Application for a Non-Material Amendment Following a Grant of Planning Permission

Erection of single storey rear/side extension with skylight, ballast weighted solar PV panels at 10 degree pitch and replace existing front door with window, following the completion of new rear extension.

R/259/21/HH

Reduction in size of extension to 5.5m x 4.5m.

DRWG No	REVISION
2021-02	3

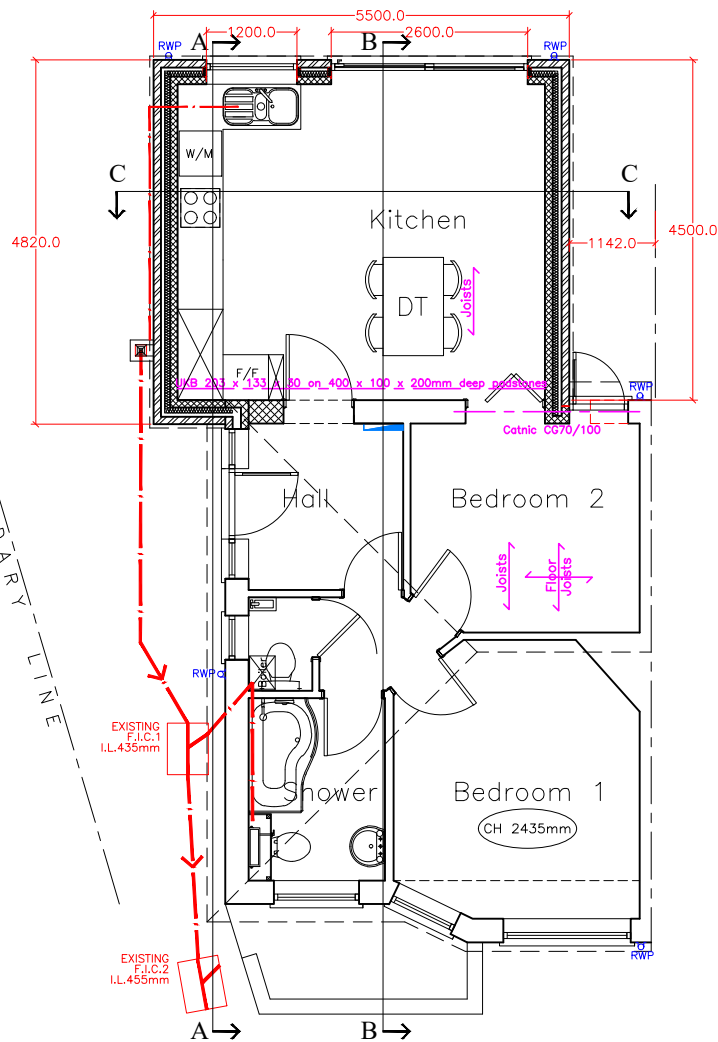
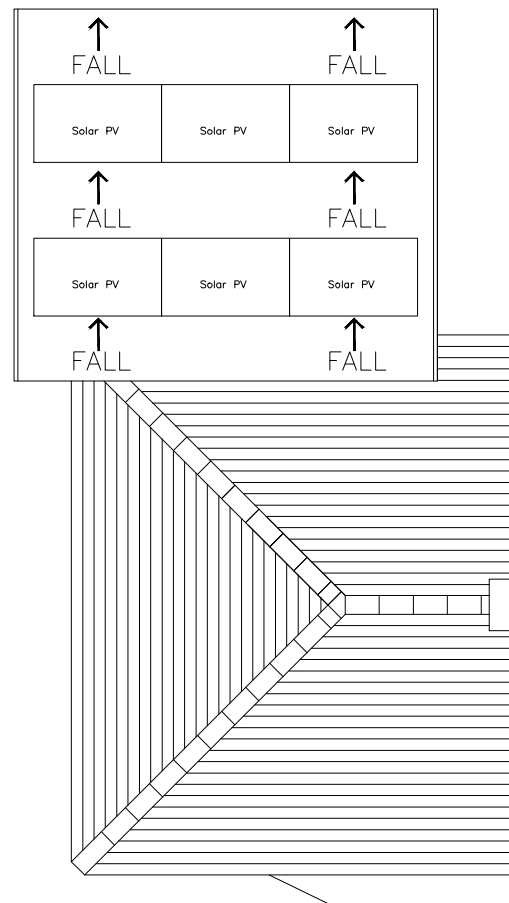
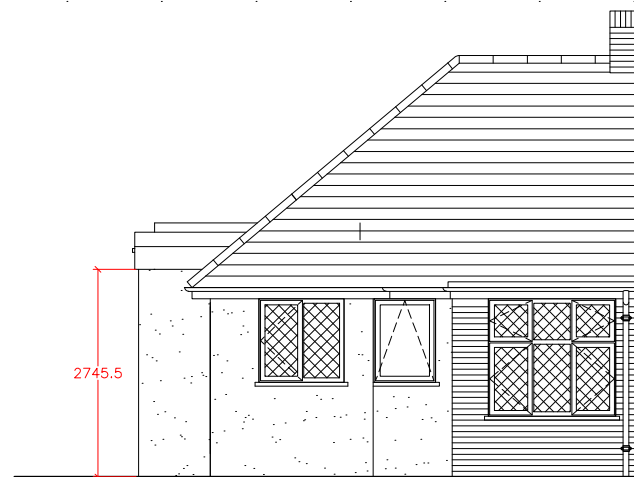
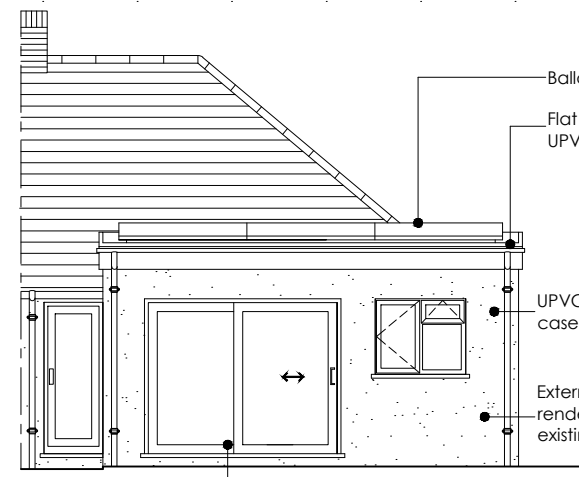
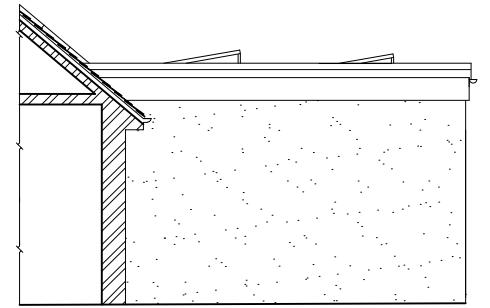
Due to the national increase in costs of construction materials.

2021-02 Revision 3
